Recommendation Report for Planning Permission for Works or Extension to a Dwelling

REF NO: M/105/20/HH

LOCATION: 22 Tudor Close
Middleton-On-Sea
PO22 6DN

PROPOSAL: Removal of existing roof structure, new first floor accommodation and pitched roof above and replacement rear single storey extension.

PROPOSED ELEVATIONS

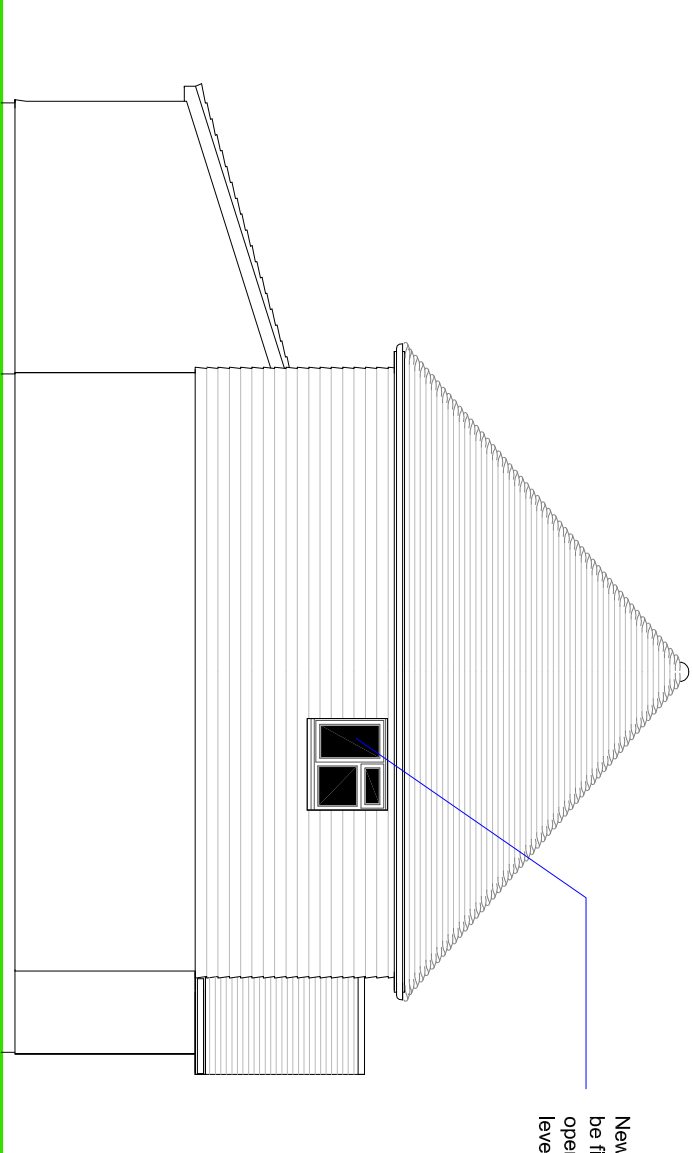
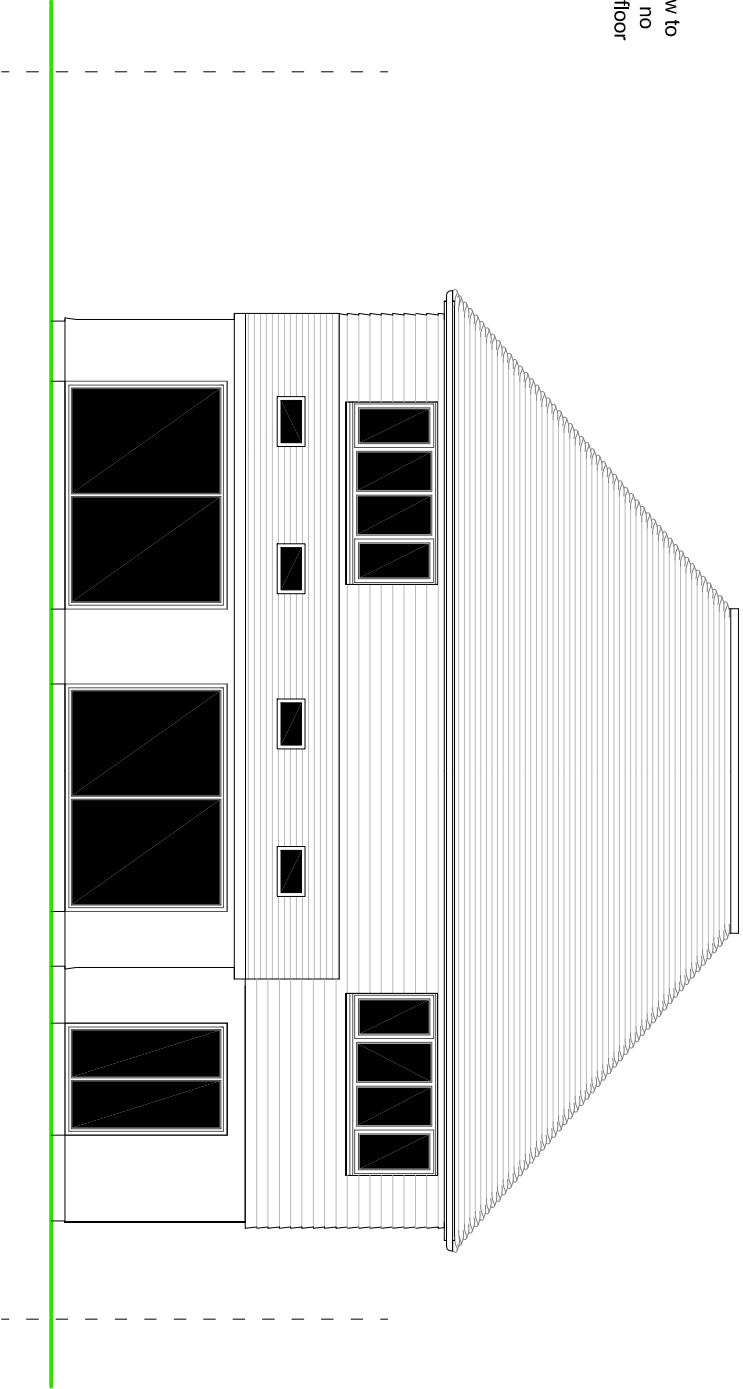
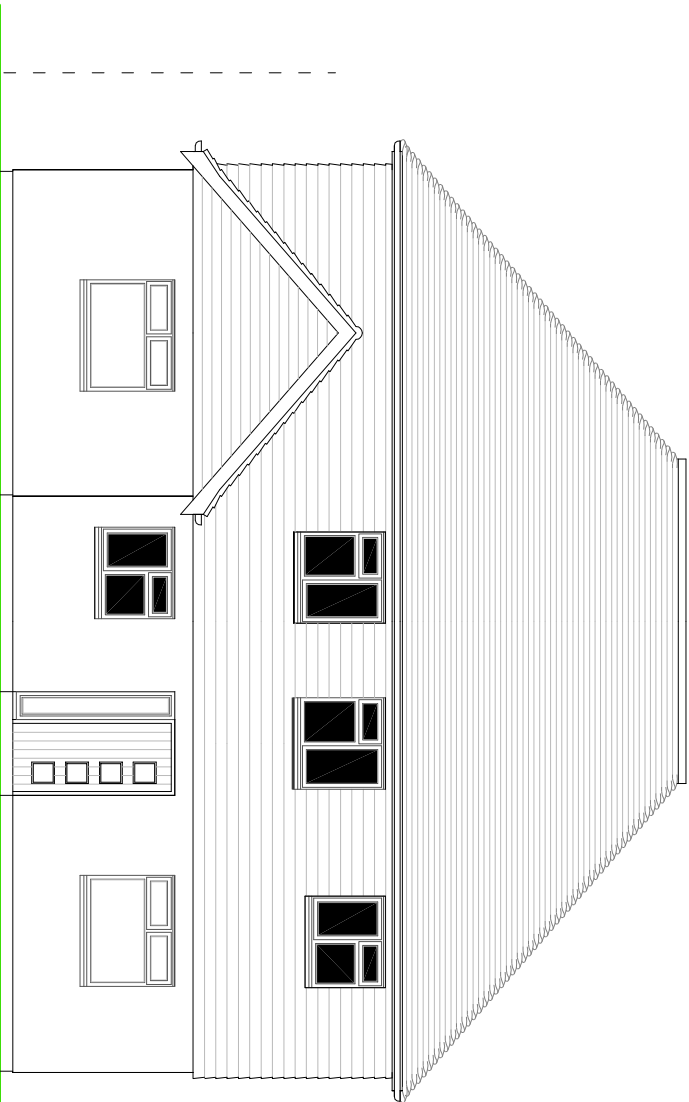
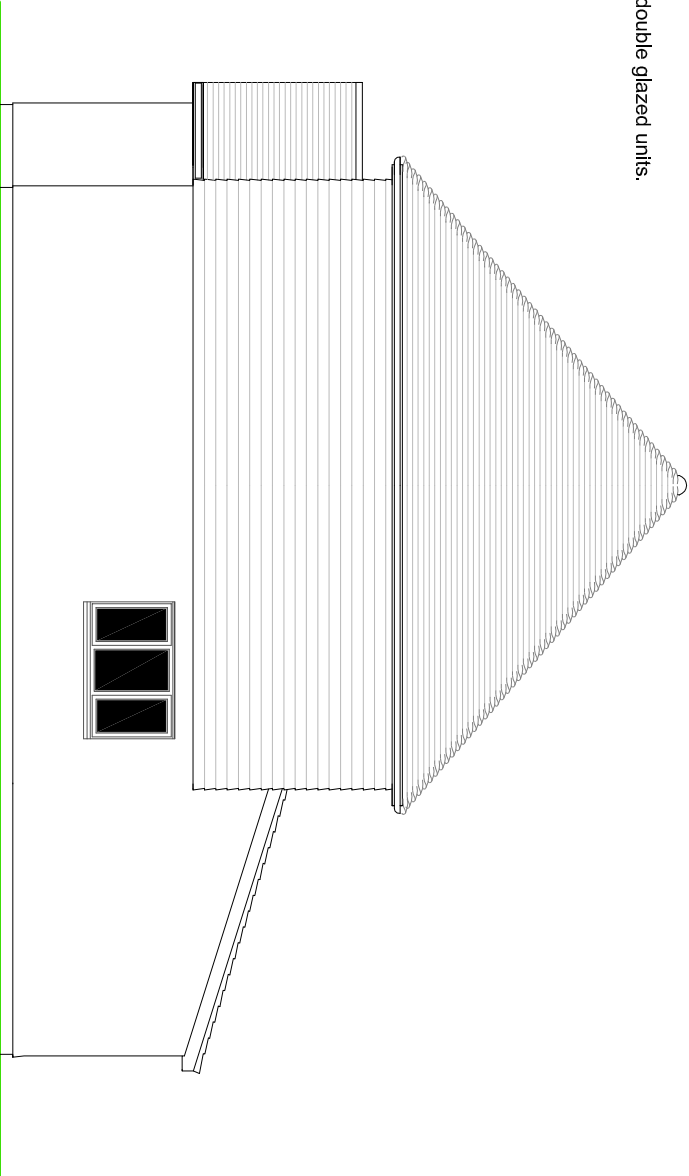
DESCRIPTION OF APPLICATION The application seeks to remove the existing roof structure, and replace with a new first floor with a pitched roof above, and a replacement single storey rear extension. The maximum roof height will increase from 6.45m to 9.1m.

The proposed development seeks to remove the roof structure of the existing host dwelling, and replace with a full first floor and new roof structure thereby increasing the height of the existing dwelling by over 2m.

This is considered to be visually harmful to both the host dwelling and the established character of the immediate locality. The proposed addition of a full first floor is considered to be visually dominant within the context of the host dwelling, and that of the wider locality, through the creation of a host dwelling which appears significantly at odds with the area.

The proposed extension is considered to overpower the existing dwelling, those in the area and the neighbouring dwellings to the East and West through its bulky design and form. As such, it is considered to be in conflict with Section M of the Arun Design Guide and policies D DM1 and D DM4 of the Arun Local Plan.

The proposed development is considered to result in a detrimentally harmful impact upon the character of the host dwelling, and the character and spatial pattern of the locality. This is due to its scale, design and siting resulting in an visually dominant proposal which overpowers the host dwelling and those in the area. This conflicts with D DM1 and D DM4 of the Arun Local Plan, and Section M of the Arun Design Guide.
